From: Lindsay Darden
Sent: Friday, July 17, 2020 5:05 PM
To: Nathan Derwick
Cc: Stephan Morin (stephan@copestone-cm.com); Nina Ruiz
Subject: PPR-19-003 Site Inspection 7/17/2020

Site Inspection Results:

WOODEN TRASH ENCLOSURE GATES

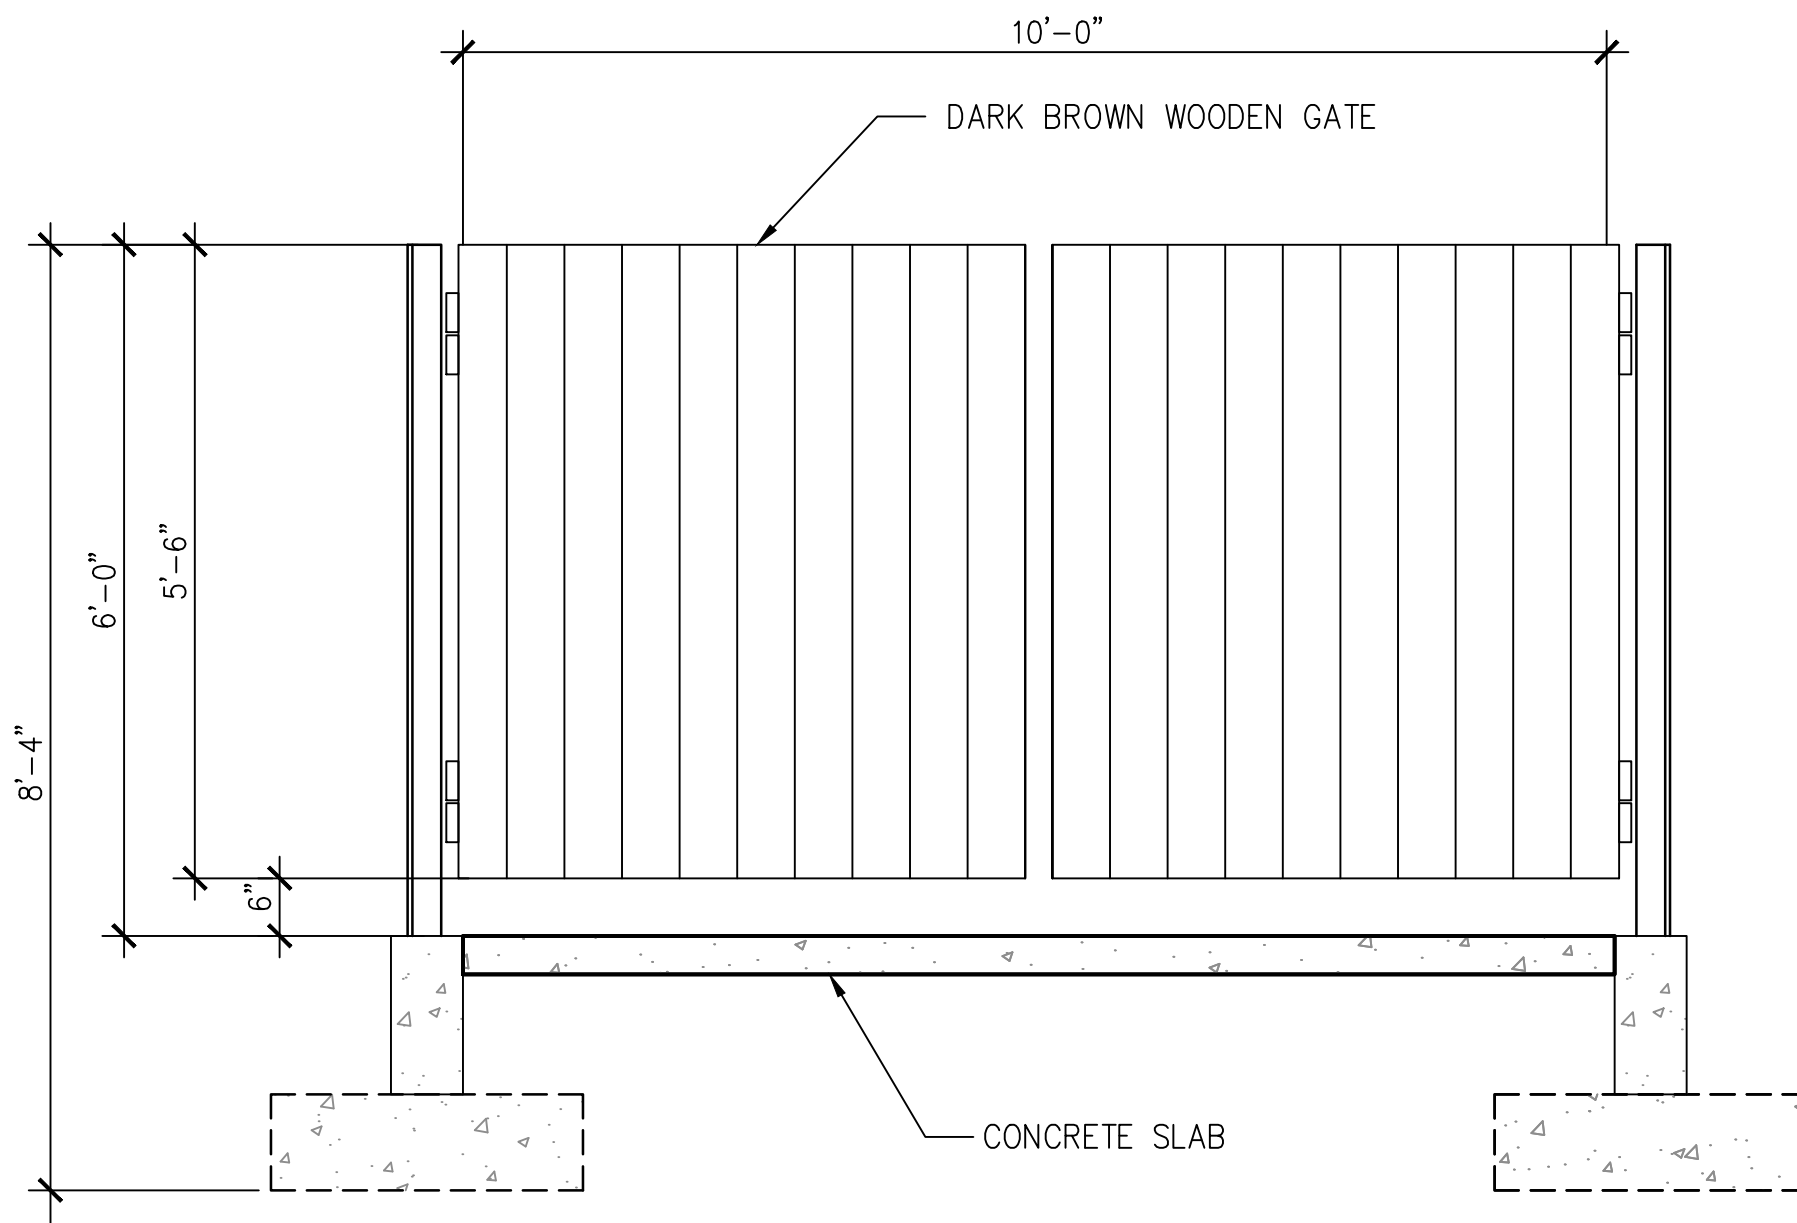
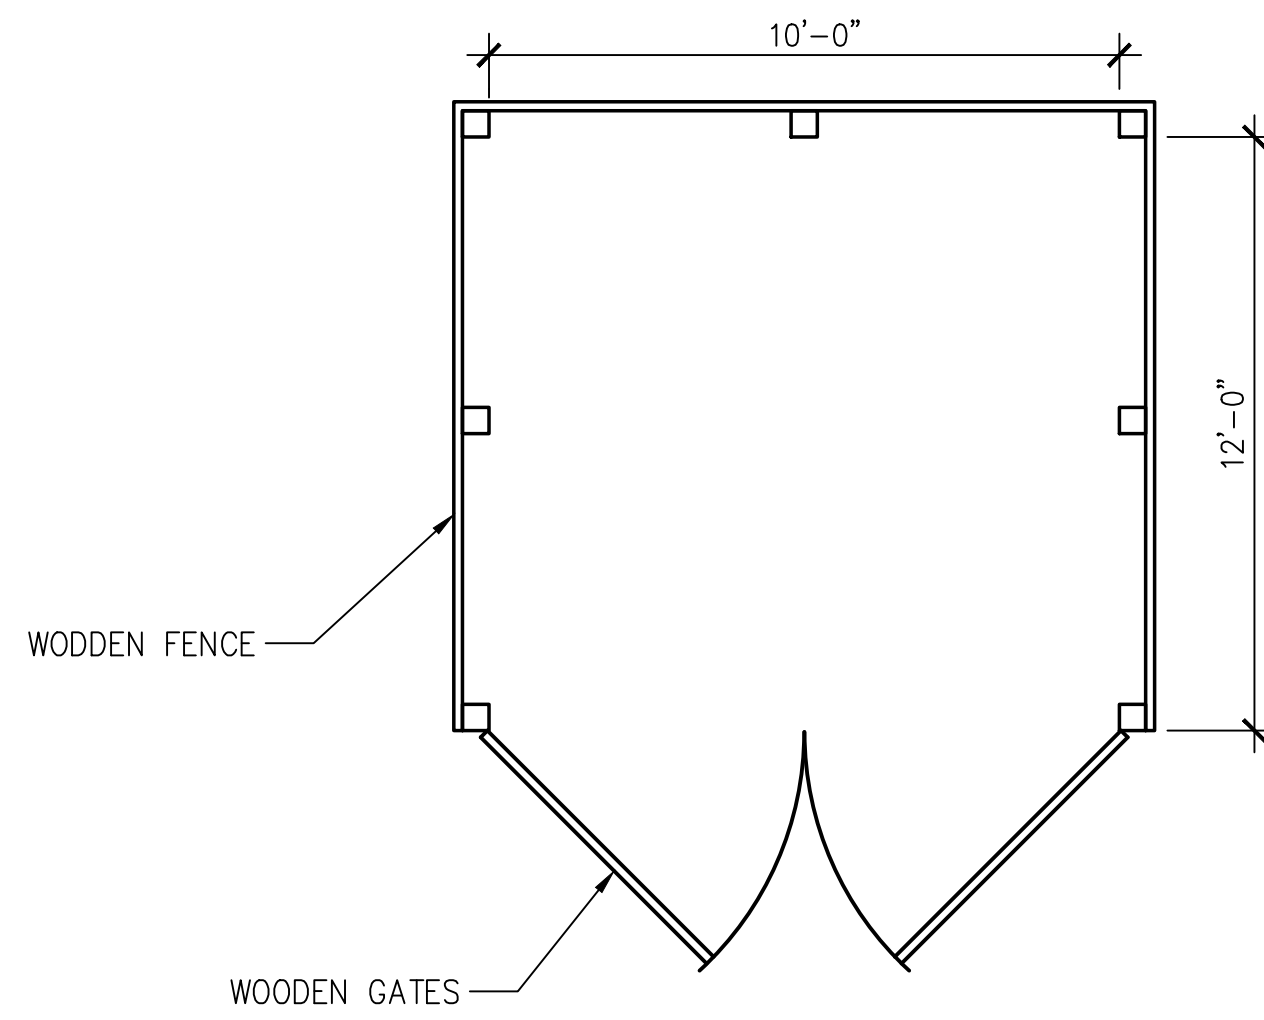
- Missing Bike Rack
- Missing Trash Enclosure Gate
- 1 missing perovskia (Russian sage) North side of the building in the planting area further east near the gate leading to the outside storage area.

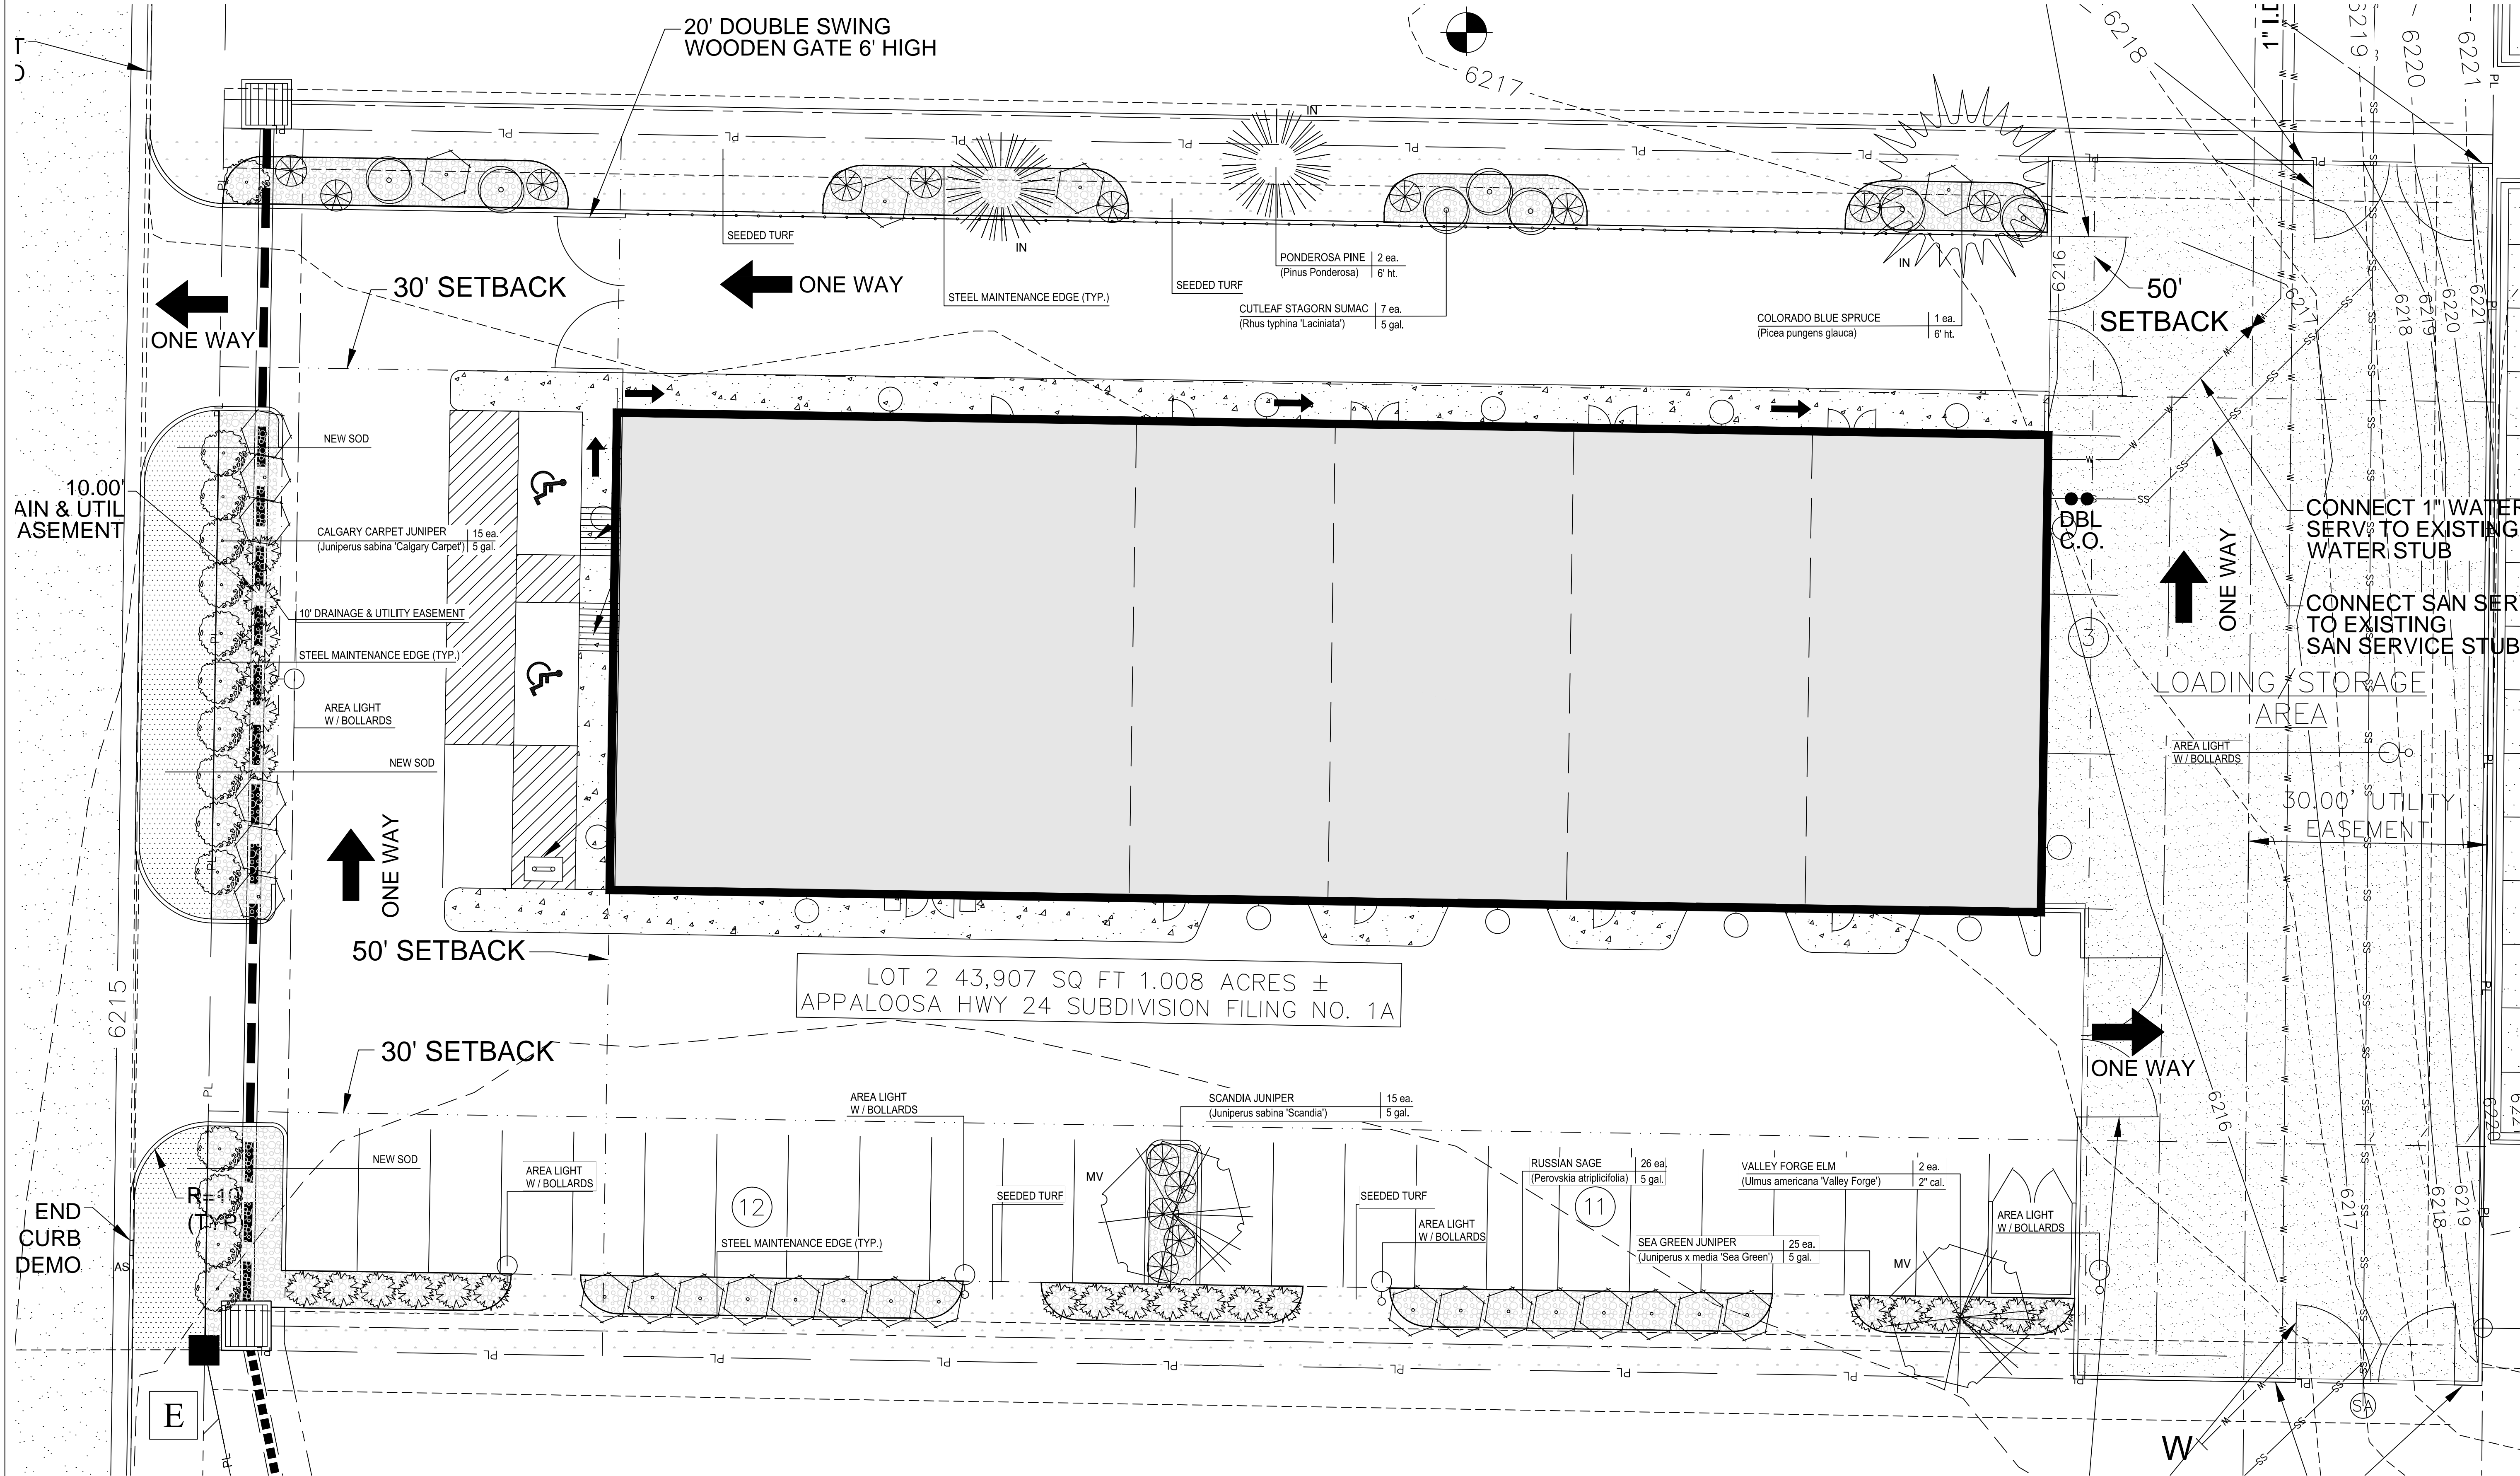
- 3 trees planted in ROW not shown on revised landscape plan – I reached out to public works to see if they will consider a license agreement to allow the trees to remain. Waiting to hear back and will follow up.

- Additional trees added to landscape area along south property line are in the drainage swale – I reached out to our engineering group to ask if this is an issue. Waiting to hear back and will follow up.

- Missing landscape island in parking area and missing landscape materials that were approved in that island
- Elevations do not match approved site plan – submittal of a COM site plan revision is needed to update the elevations. I will set this up and send an EDARP submittal request on Monday.
